The Secretary  
NSW Department of Planning, Industry and Environment

18 March 2021

I refer to the Department's below email of 16 March 2021 regarding the notice of exhibition of the Environmental Impact Statement (EIS) for State Significant Development SSD-8571481 TAFE NSW Construction Centre of Excellence at TAFE NSW Nepean Kingswood campus at 2-44 O'Connell Street, Kingswood (Lot 1 DP 866081). Submissions need to be made to the Department by 14 April 2021.

**Subject:** Notice of Exhibition - TAFE NSW Construction Centre of Excellence (SSD-8571481) - Endeavour Energy

LOWER GROUND - GA FLOOR
PLAN

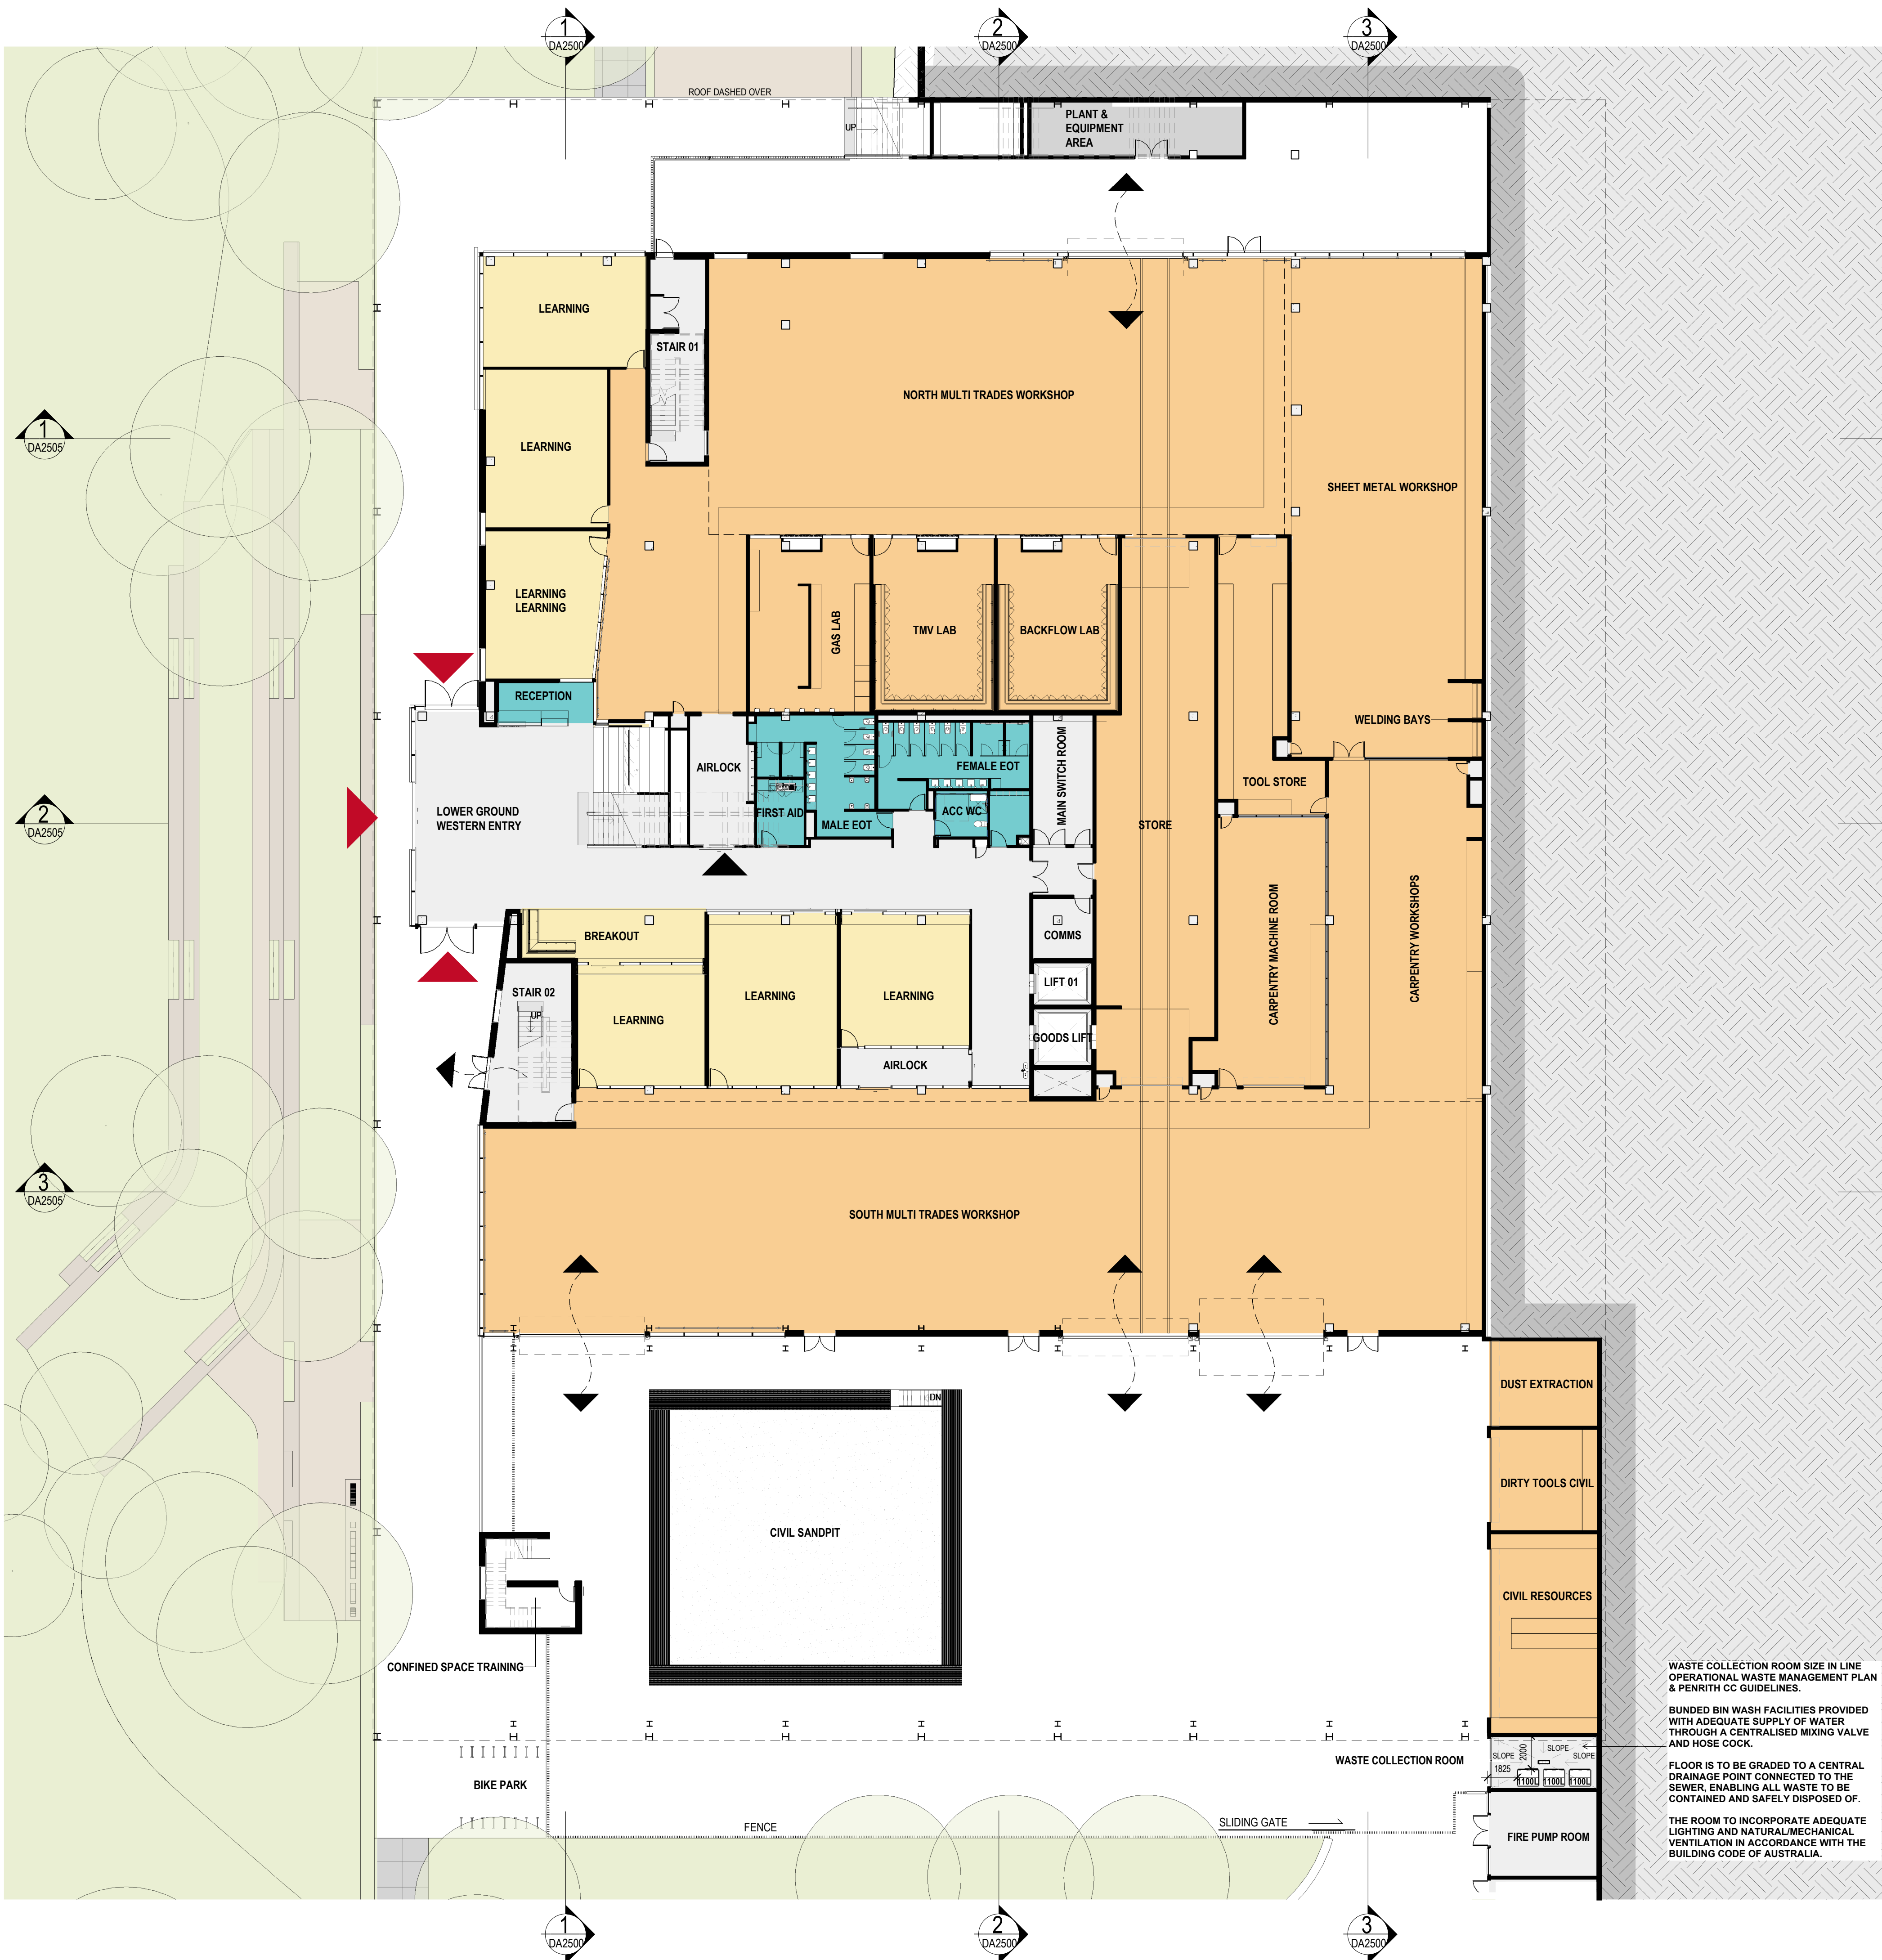
Endeavour Energy has also noted that whilst not shown in the Architectural Plans, as shown in the following extract of Landscape Plan 1 - Lower Ground provision has been made for a 'Proposed Substation Location'.
